Consultation Response from: KC Environmental Health (Pollution & Noise Control)
2020/90632 - 103 New Street, Huddersfield HD1 2TW
Discharge condition 9 (construction method statement) and 13 (ventilation scheme) on previous permission 2019/92127 for variation of condition 2 (plans) on previous application 2017/93886 for erection of extensions and alterations to convert existing building to student accommodation
Date Responded:
29 Sep 2020

Condition 13 – Ventilation Scheme

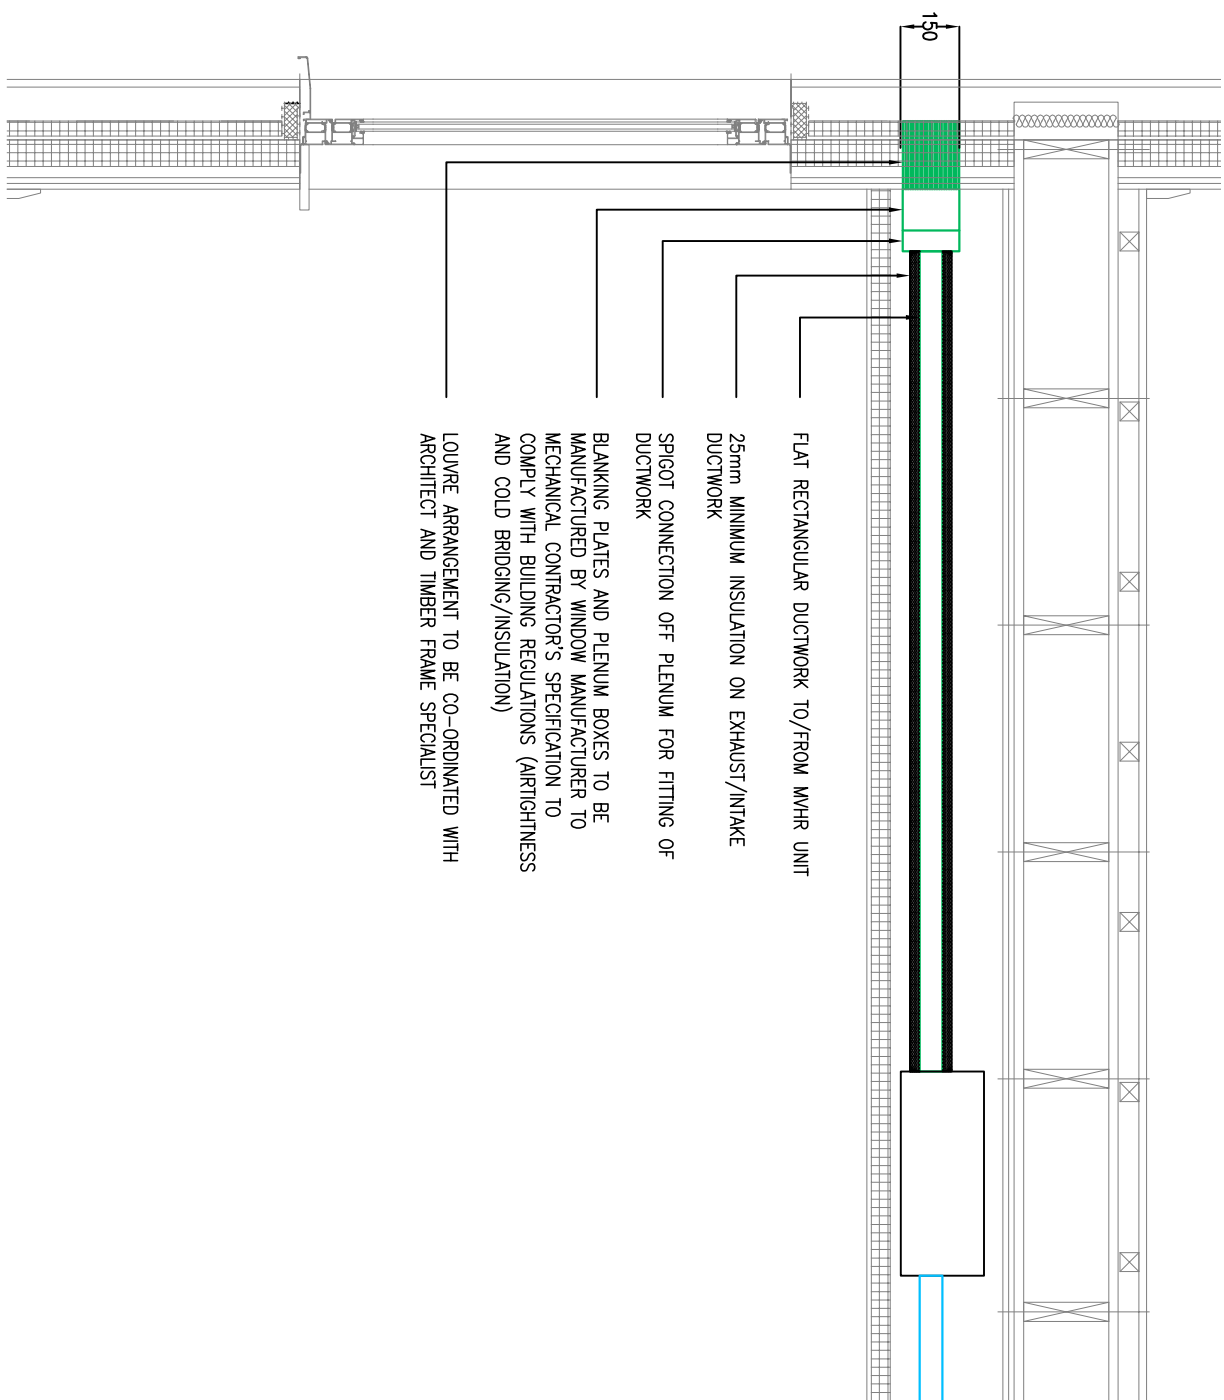
Although the report refers to the approved noise assessment it fails to take full account of the recommendations of that report and also the requirements of condition 13. In particular the noise assessment report advises in Table 9 and Figure 3 that acoustic glazing is required throughout the whole development. For the acoustic glazing to provide the required level of noise attenuation the window needs to be kept closed. Condition 13 clearly states that the required ventilation system needs to show how noise affected rooms "*shall be ventilated without the need to open windows*". Therefore, the proposal for achieving purge ventilation by opening windows negates the necessary noise mitigation measures and is also contrary to the requirements of condition 13.

The required ventilation system must be sufficient to provide levels of ventilation that is normally provided by open windows. This is particularly important in hot weather when ventilation is required to provide cooling to prevent overheating. Therefore, to be acceptable, the ventilation system must incorporate a bypass facility for any heat exchanges otherwise in hot weather incoming air will be heated in the heat exchange by the outgoing warm air and will therefore not provide the required cooling effect.

The poor air quality on the southern part of the development also needs to be taken into account with the design of ventilation system. The proposals for providing NO_x filters to the air intakes at areas of the development located where the National Air Quality Objectives are exceeded are noted. If this proposal is to be repeated then the specification of the proposed filters needs to be provided with details of the proposed ongoing maintenance of the filters that will be necessary. A lower maintenance alternative option of having all of the air intakes away from areas of poor air quality should ideally be considered.

For the reasons detailed above I consider that the submitted information is insufficient to meet the requirements of condition 13 and therefore recommend that condition 13 should not be discharged at this time.
